Mark E. Jones, PE  
Structural Engineering and Design

Ref: Site Observations and Analysis  
2437 NC55 N  
Dunn, NC  
Project No: 19-275

Plans for the above referenced site were reviewed on August 27, 2019 and the site was observed on November 15, 2019 to address the following structural concerns and clarifications:

FIRST FLOOR PLAN
SCALE 1/4" = 1'-0"

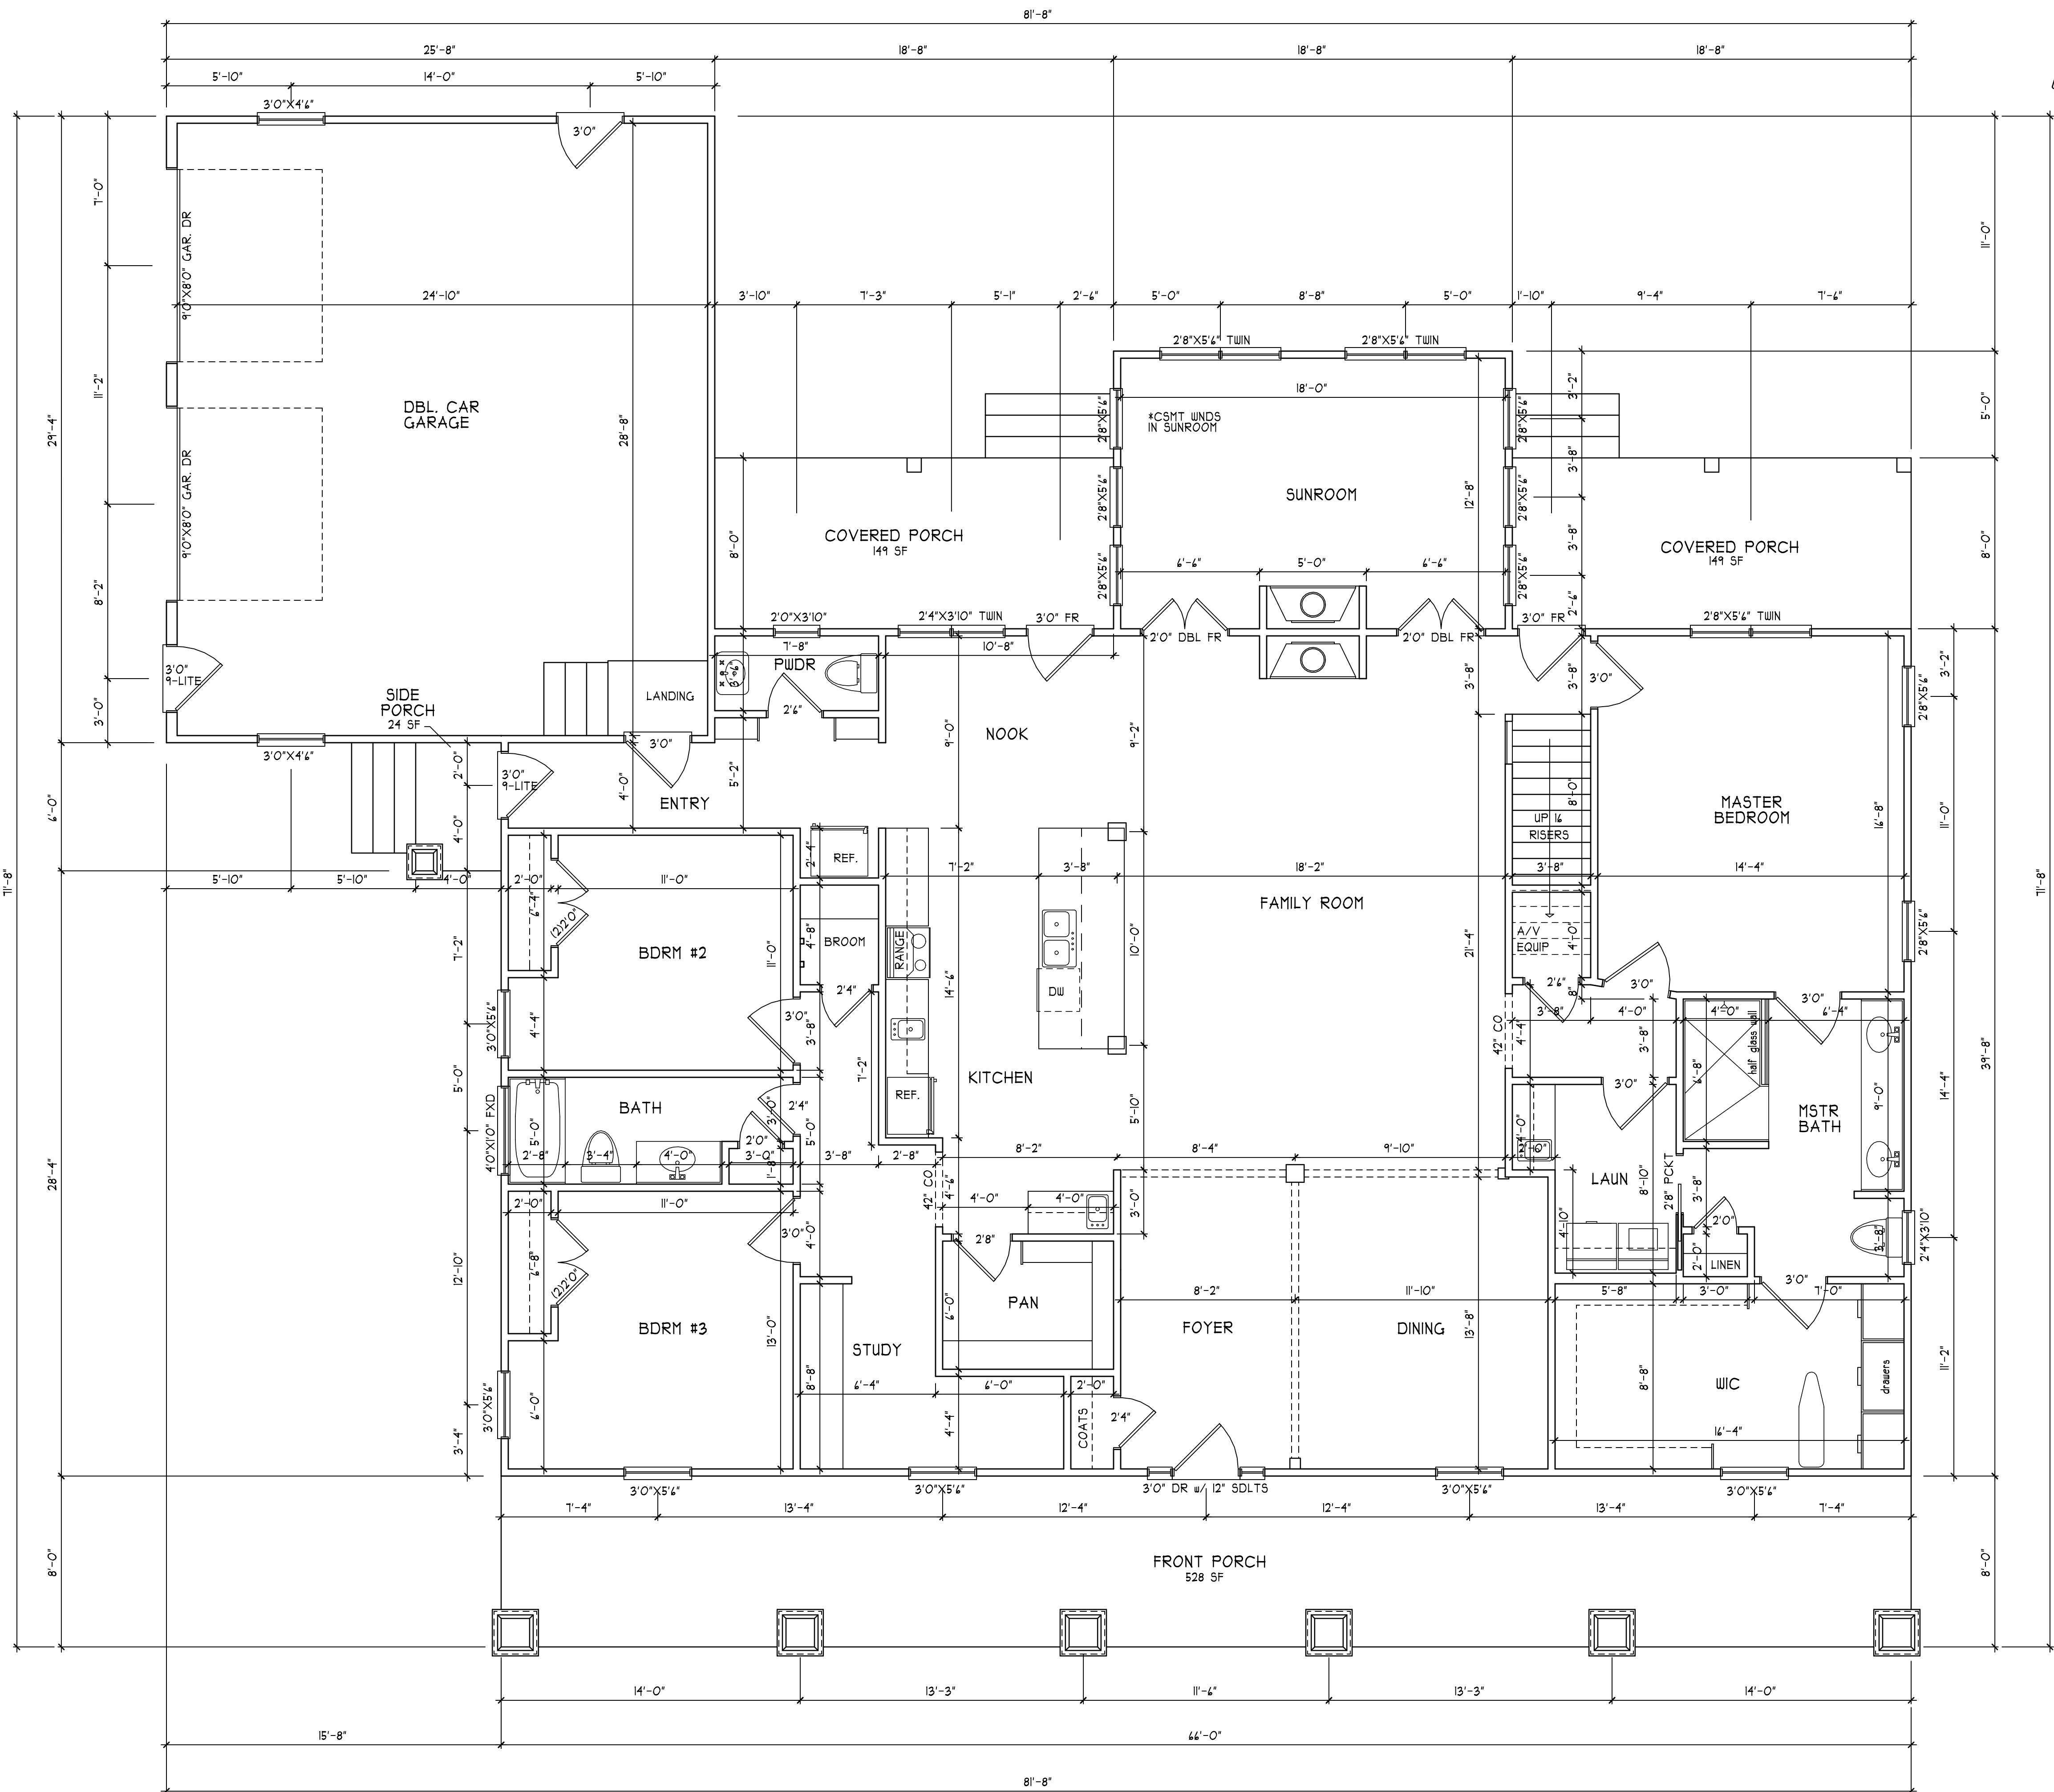
1. Owner wants to eliminate column at kitchen island.
2. Engineer to address windows at sunroom not per plan.

1. To eliminate the column at the kitchen island, the builder was instructed that a W23X55 steel beam would be required to support the imposed loads. The beam was to be supported by a 3" diameter steel column at each end with solid blocking in the floor system to the foundation below. The beam and supports have been installed per specifications.
2. In lieu of the two sets of twin windows indicated at the rear wall of the sunroom, five single windows have been installed with double stud pockets between them and a continuous 2x10 header with straps at each end. The existing construction is portal framed and adequate to support/resist the imposed design loads. No further action is required.
